ENG-PUDSP21010-R4-PDR.pdf Markup Summary

## SWALE A-4a

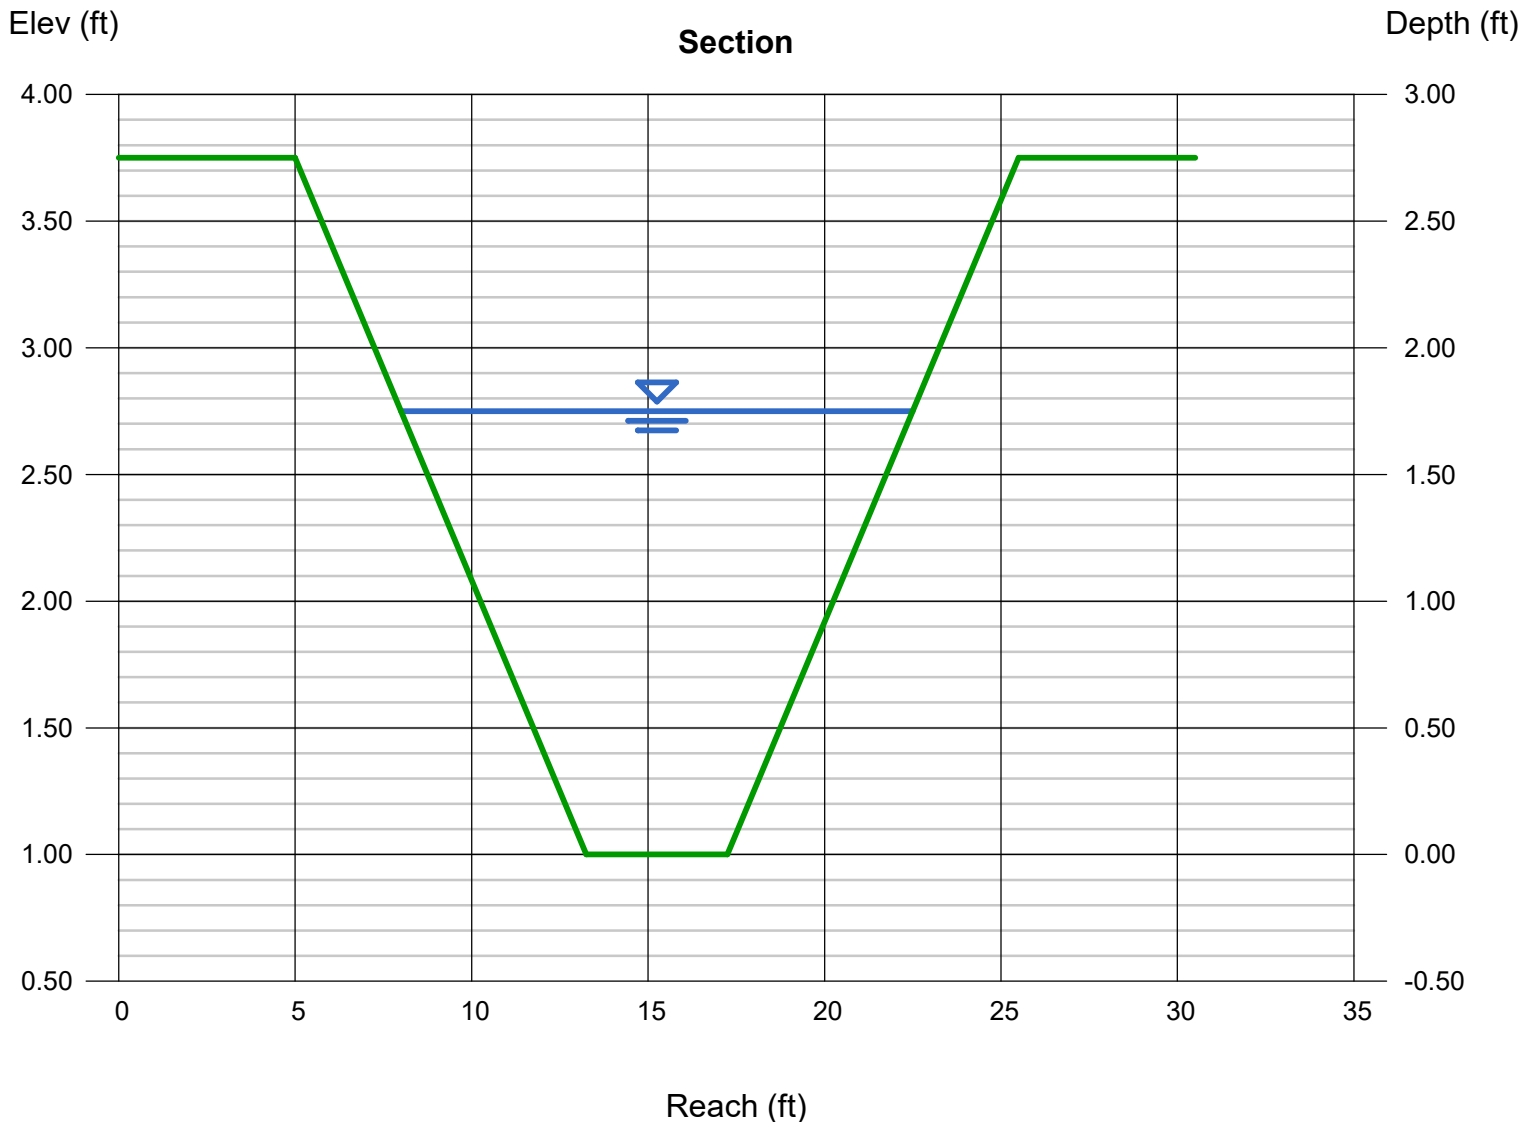
Address the Eastonville Road culvert crossings into Basins D1, E1, and A-4a

Side slopes? Provide cross sections of swales on drainage plan.

## SWALE BASIN C-7a

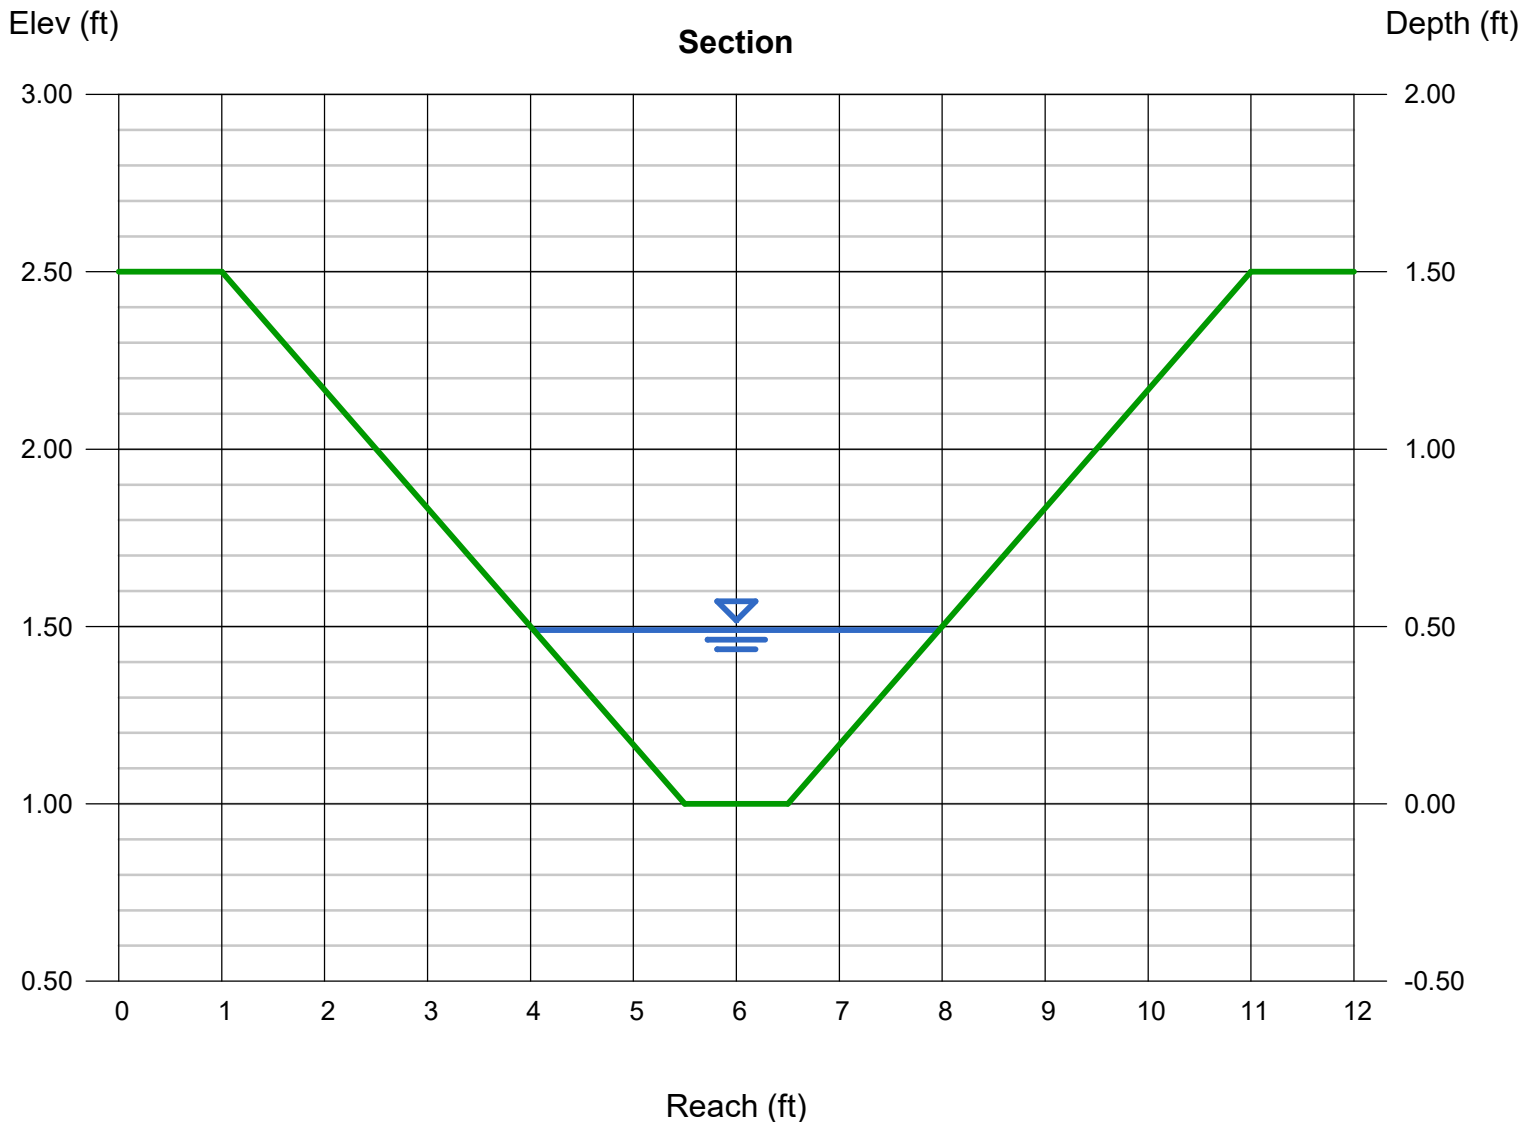
Label if this is for Sidewalk Chase not actual
swale, which is next sheet

**PROPOSED DRAINAGE MAP**

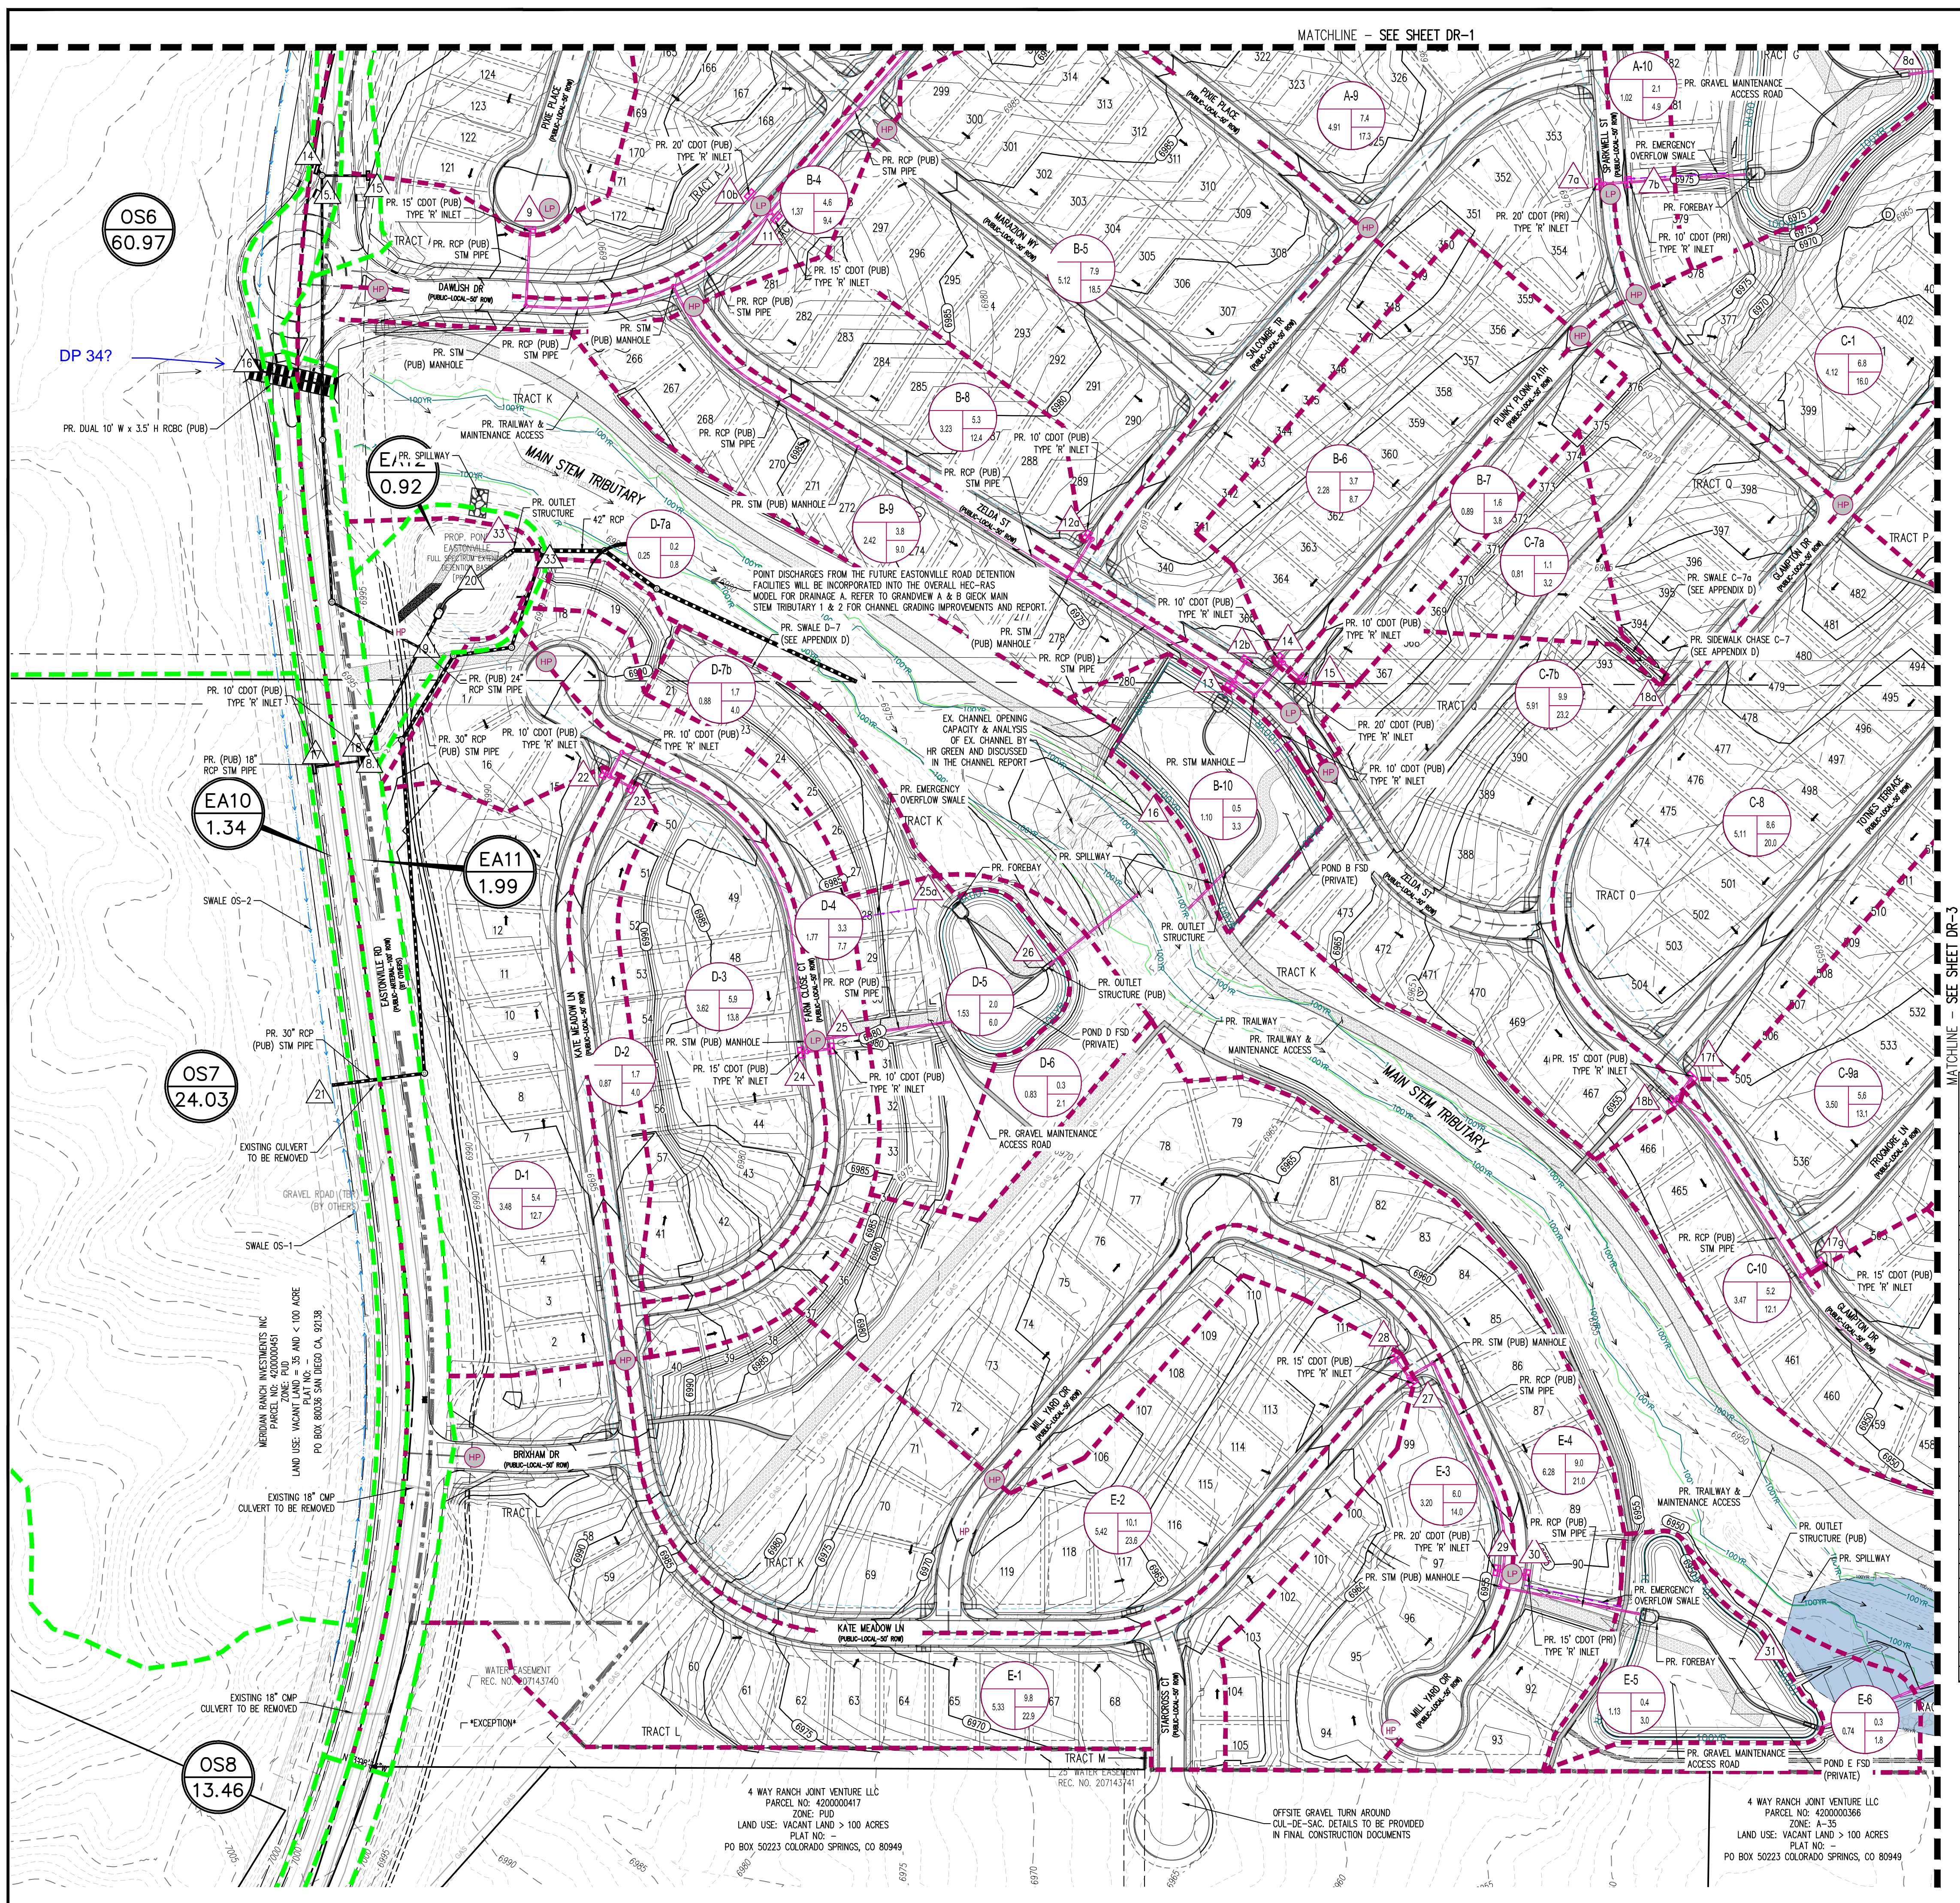
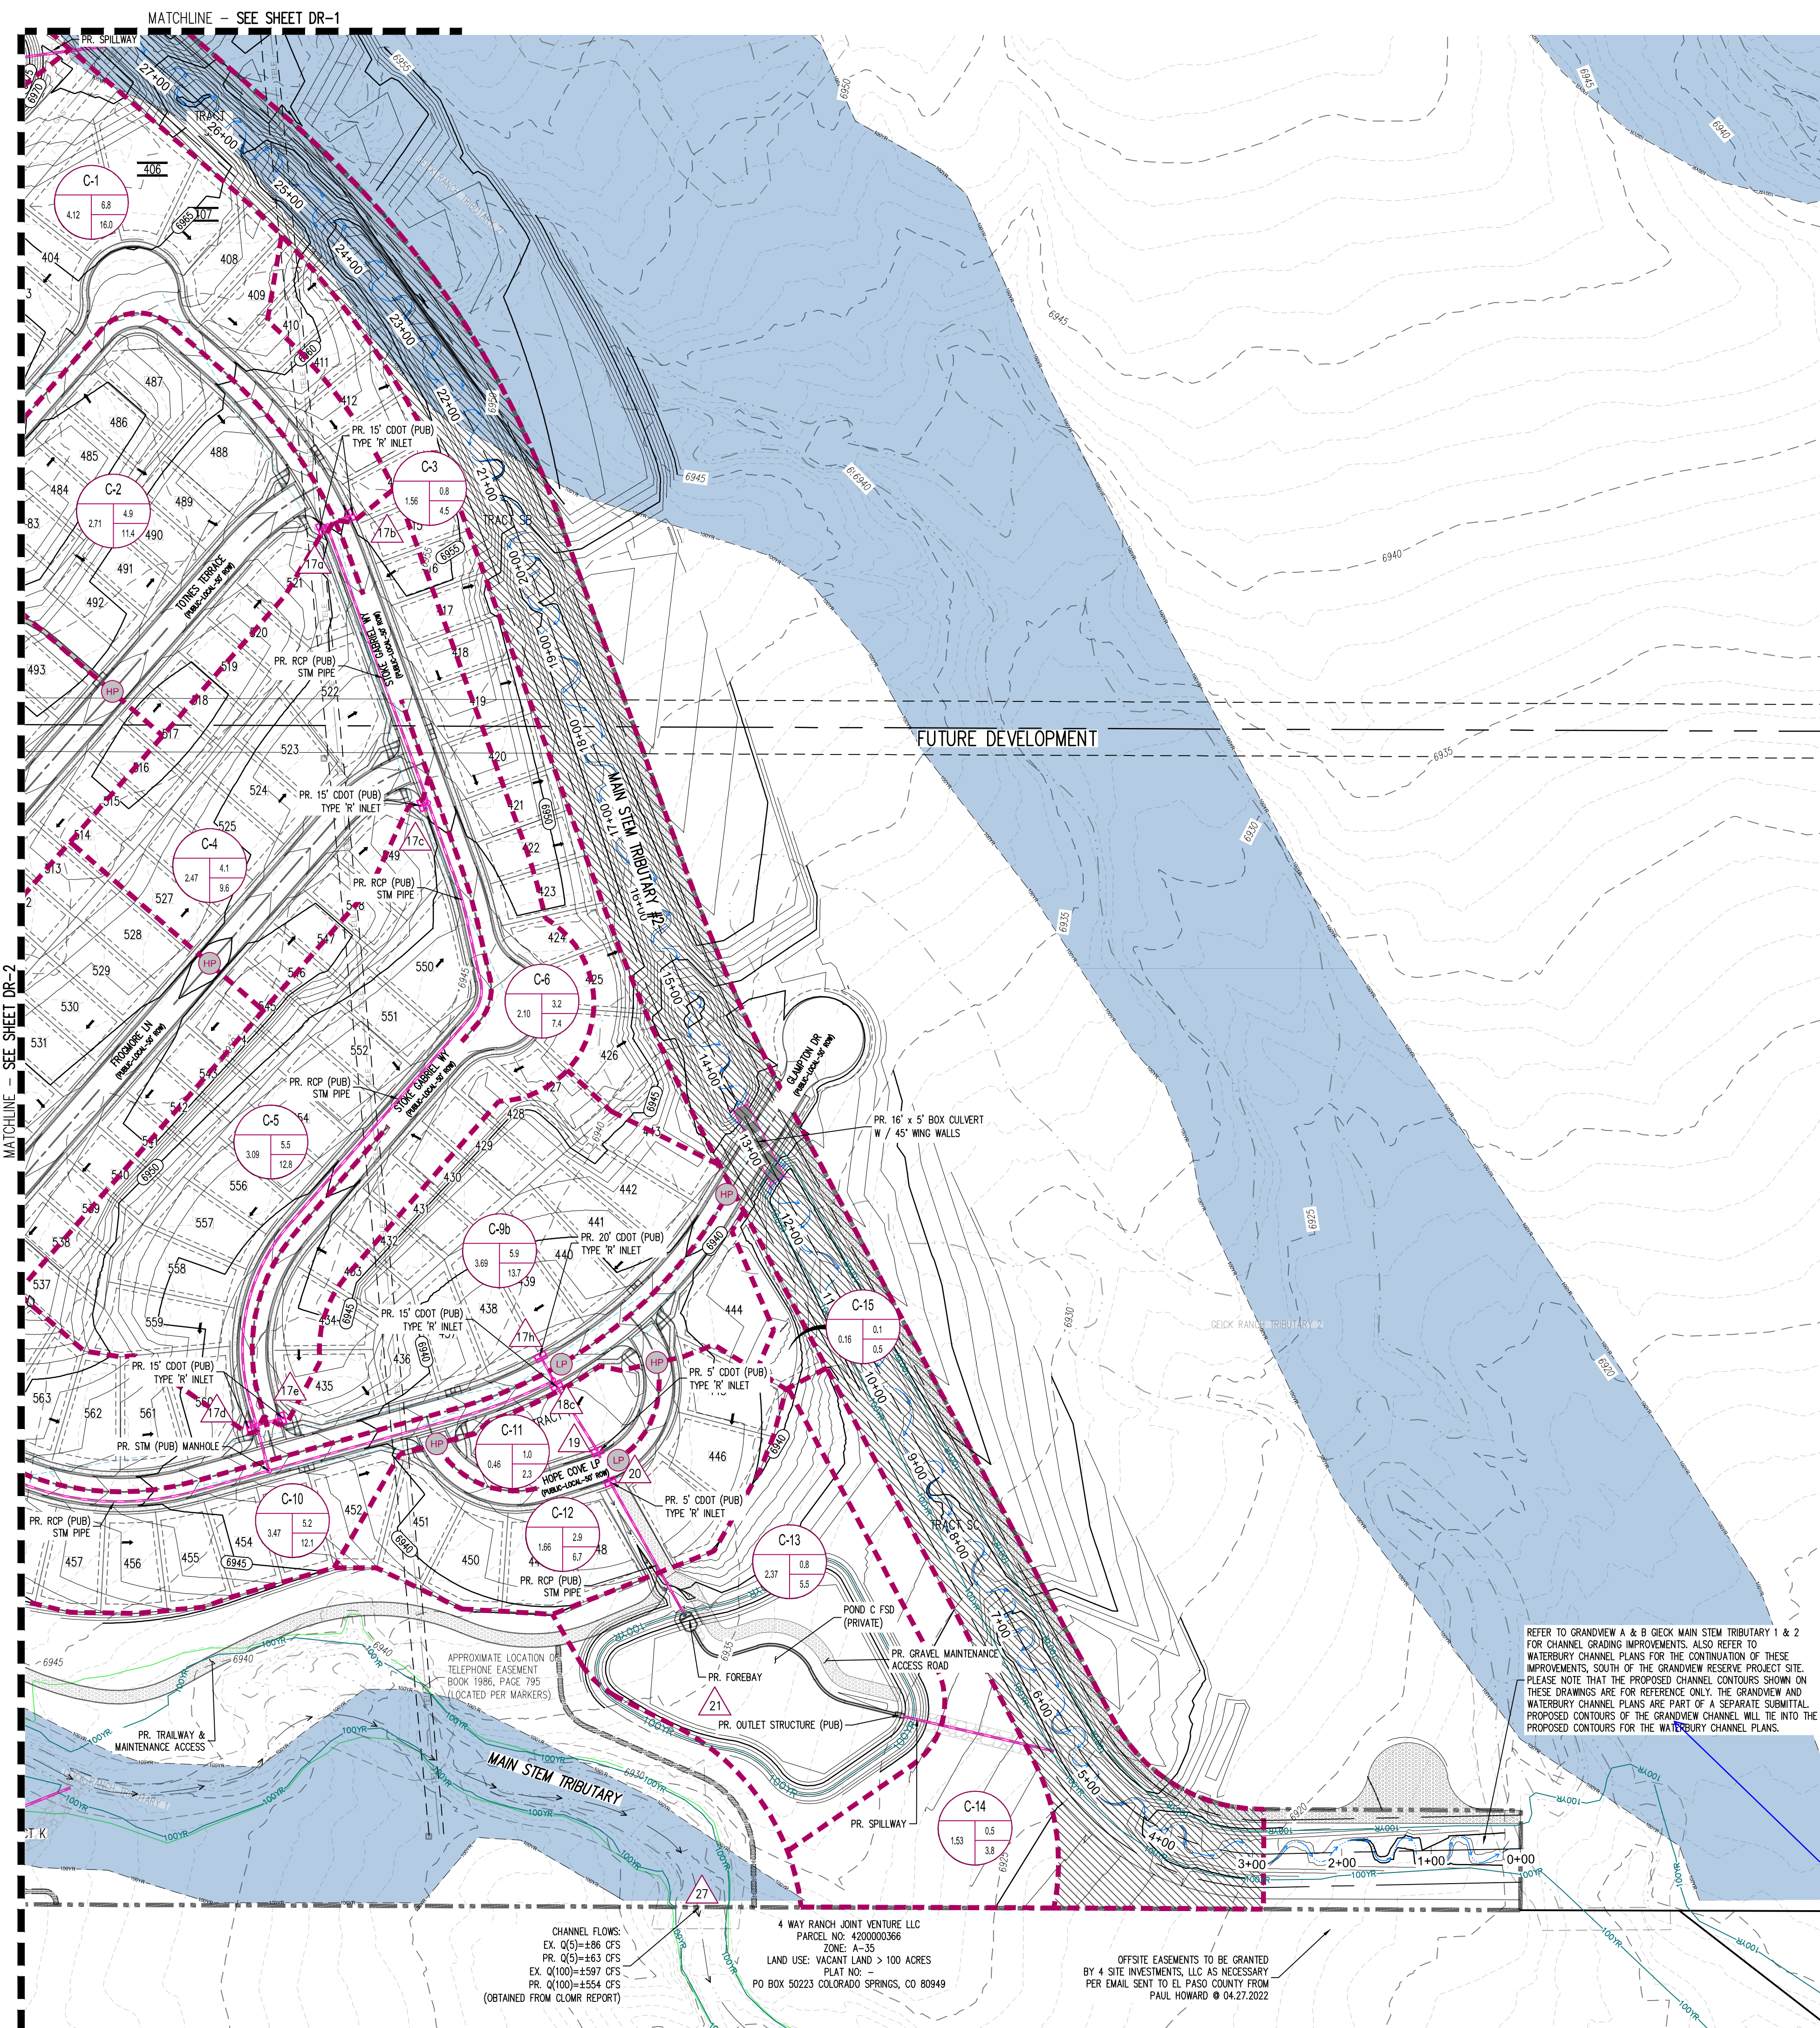
Basin map calls for 10' inlet and inlet sizing is missing in appendix. Please provide sizing spreadsheet and reconcile inlet size between map & report.

Update to match DP designations used on Drainage map.

Update labels to match report and calculation sheets
